Subject: Cloud+
Page Label: [1] 61090-CON-GEC-CS-C-1
Lock: Locked
Author: dsdrice
Date: 10/2/2018 12:30:58 PM
Color: ■

PPR-18-040

DATE: August 20, 2018  
PROJECT NUMBER: 17150  
MVE PROJ NO. 6196 DWG - CON-GEO-GP  
COPYRIGHT © 2018 VECINO DESIGN BUILD

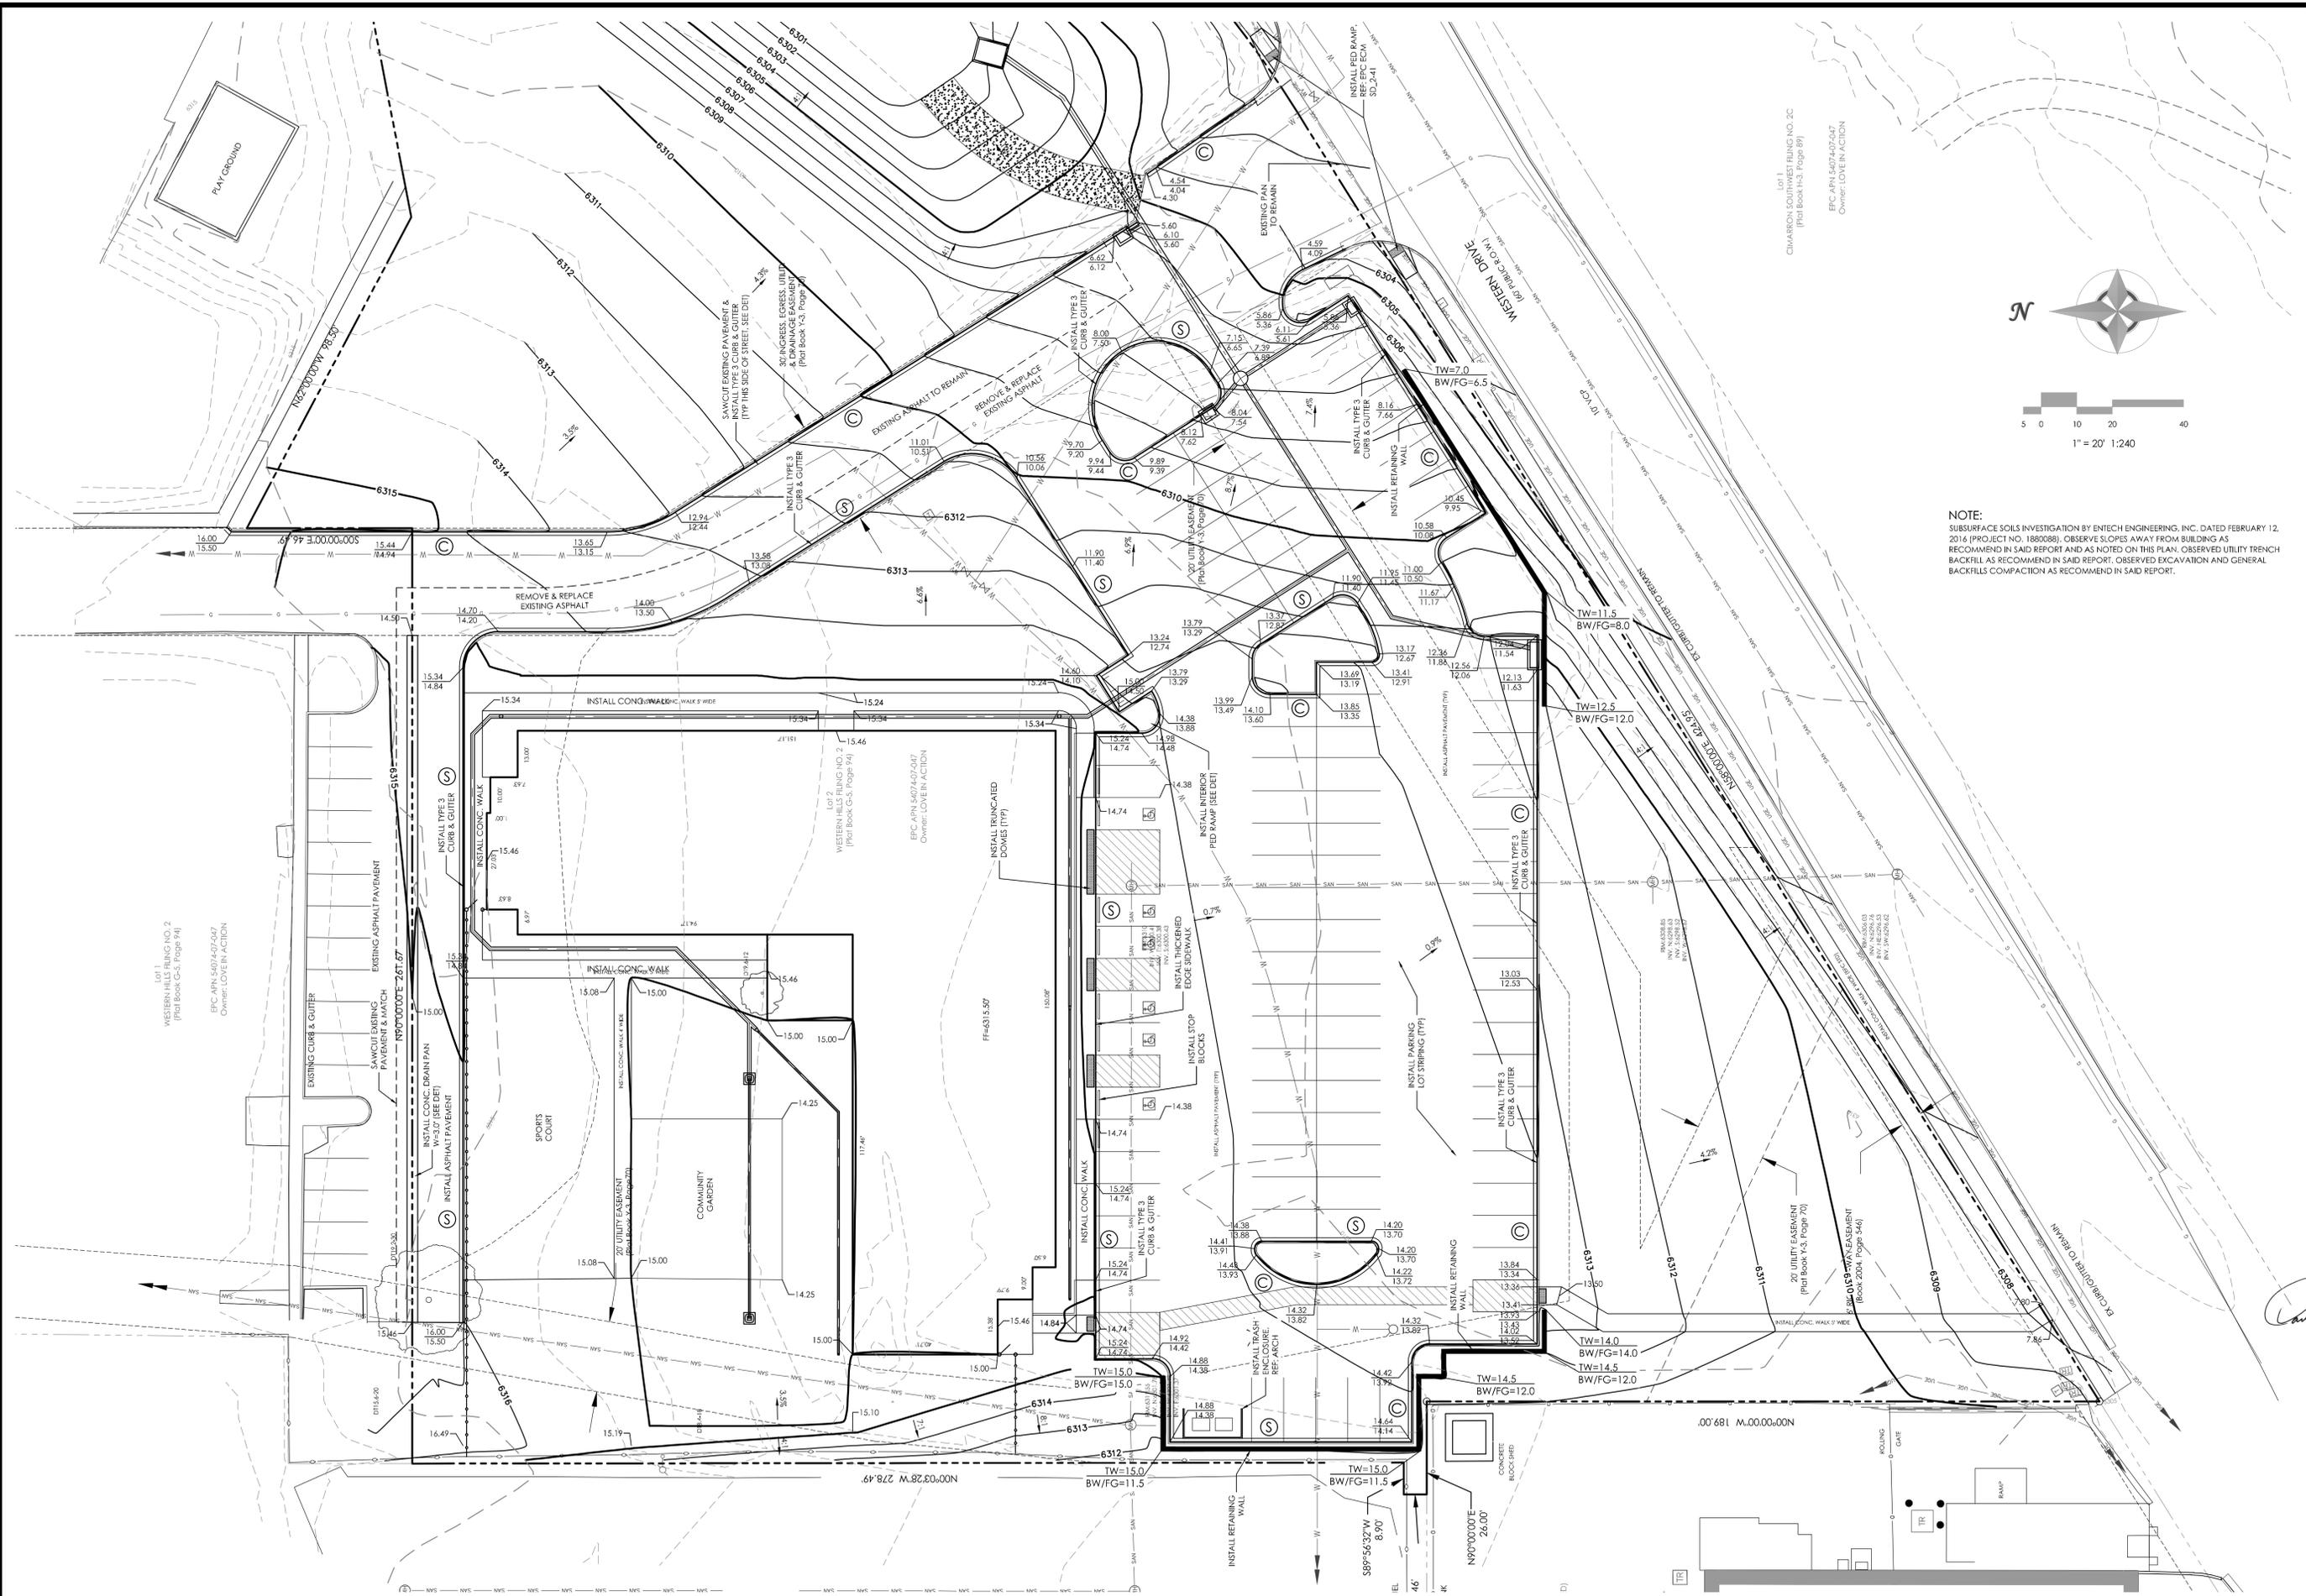
Change in flow direction - will this affect adjacent properties?

**C-3**

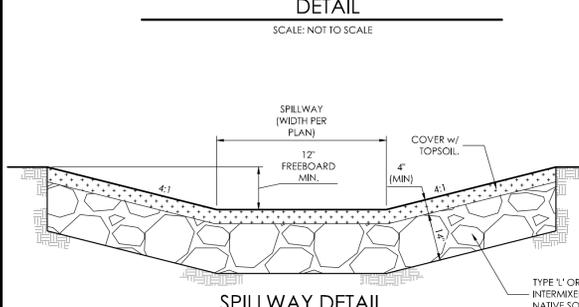
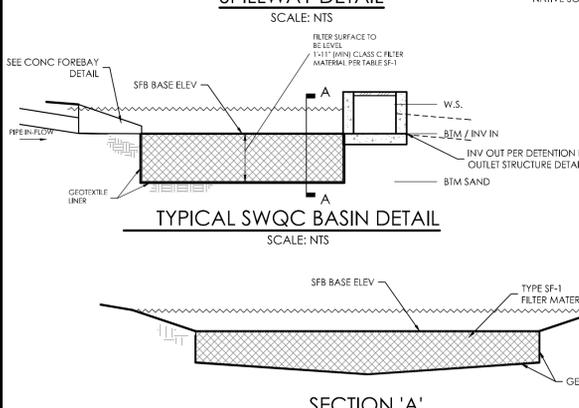
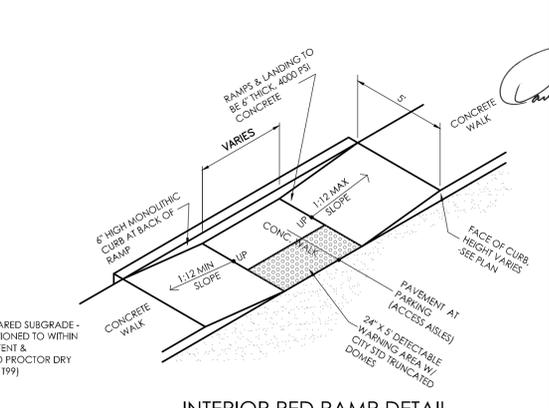
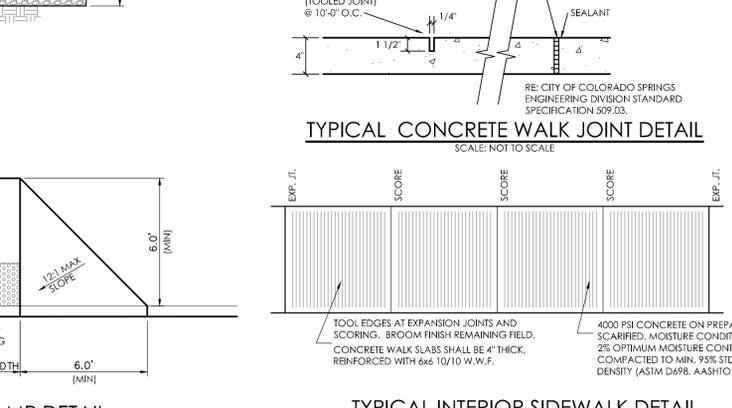
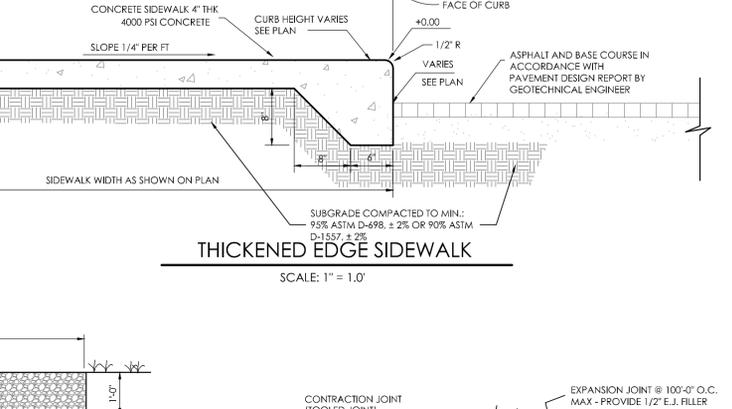
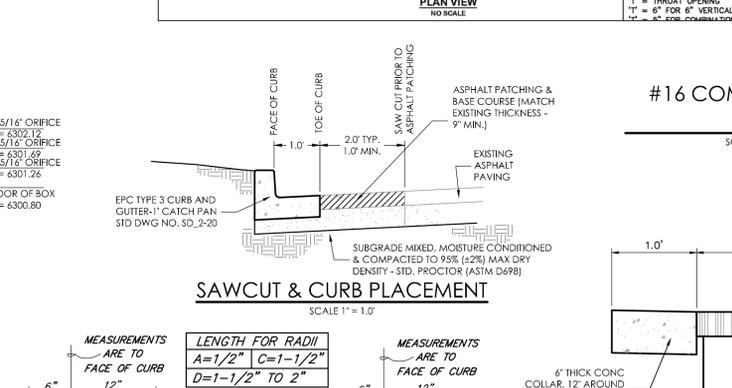
per ECM SD 3-25

Erosion Control Plan

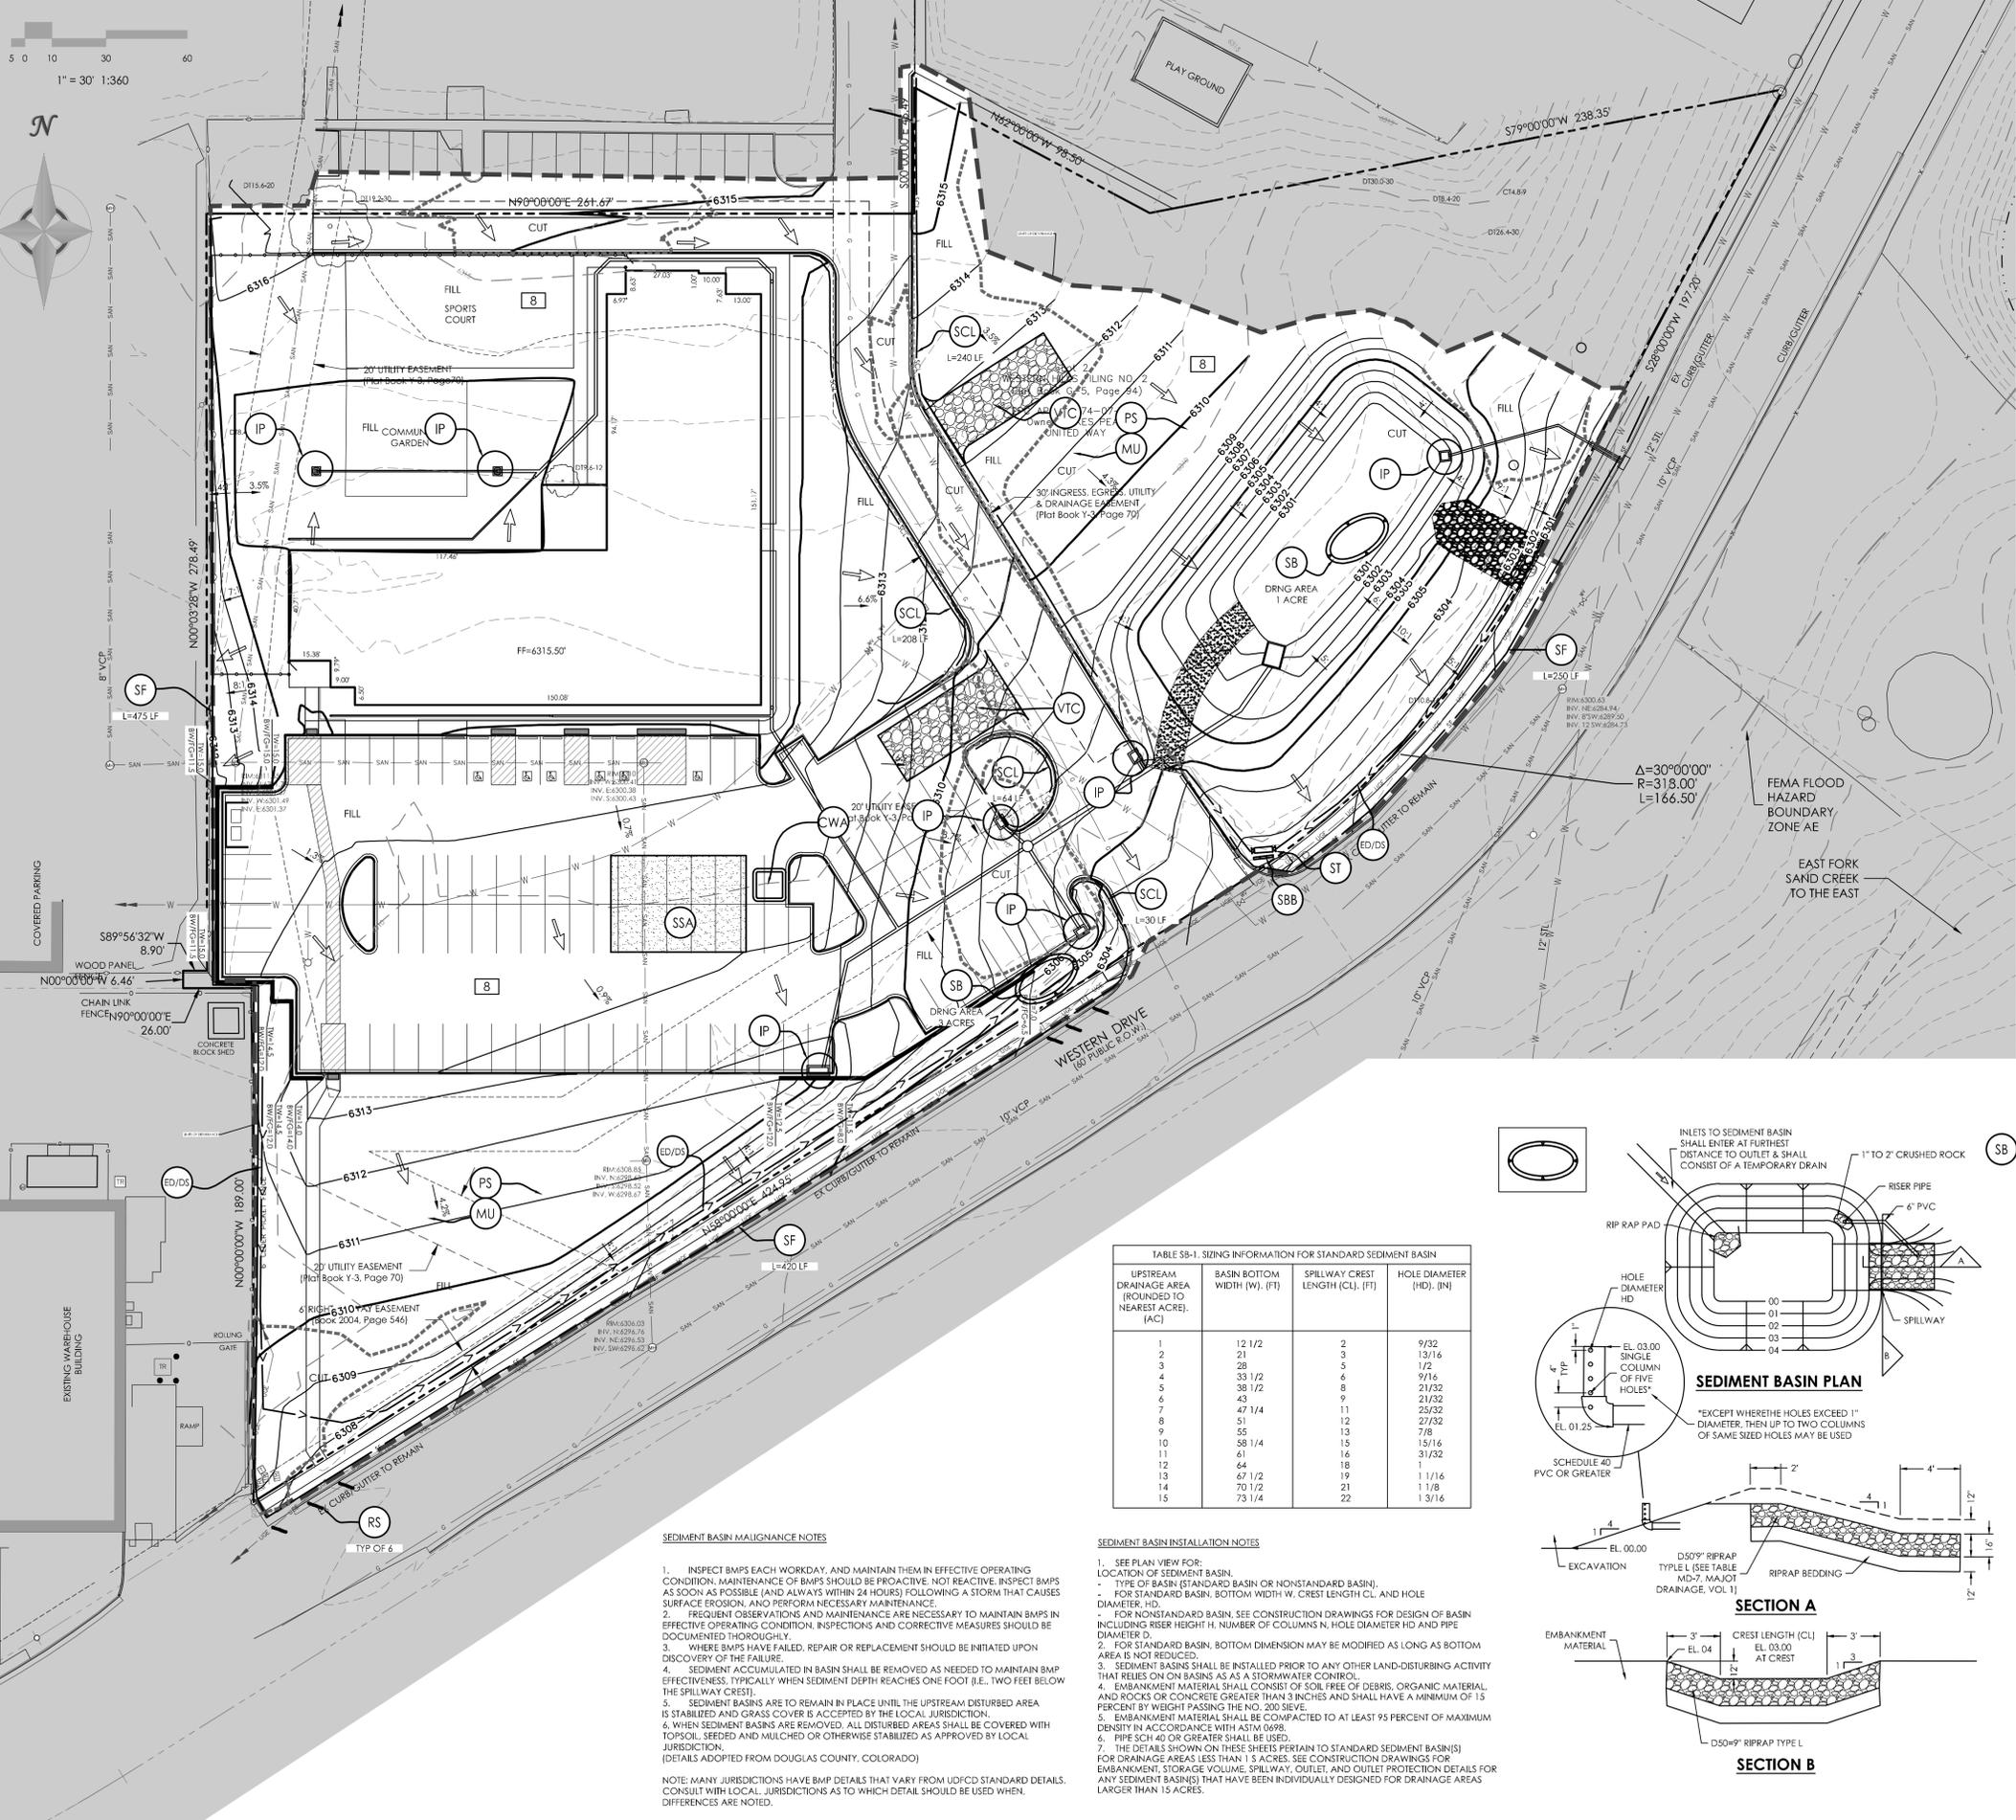
Enlarge linetype symbols

Permanent seeding? or sod?

Permanent seeding?

East Fork Sand Creek

Add notes regarding existing vegetation, batch plants, retaining walls, etc. -- see checklist.

Label slope

VTC

provide flow arrows
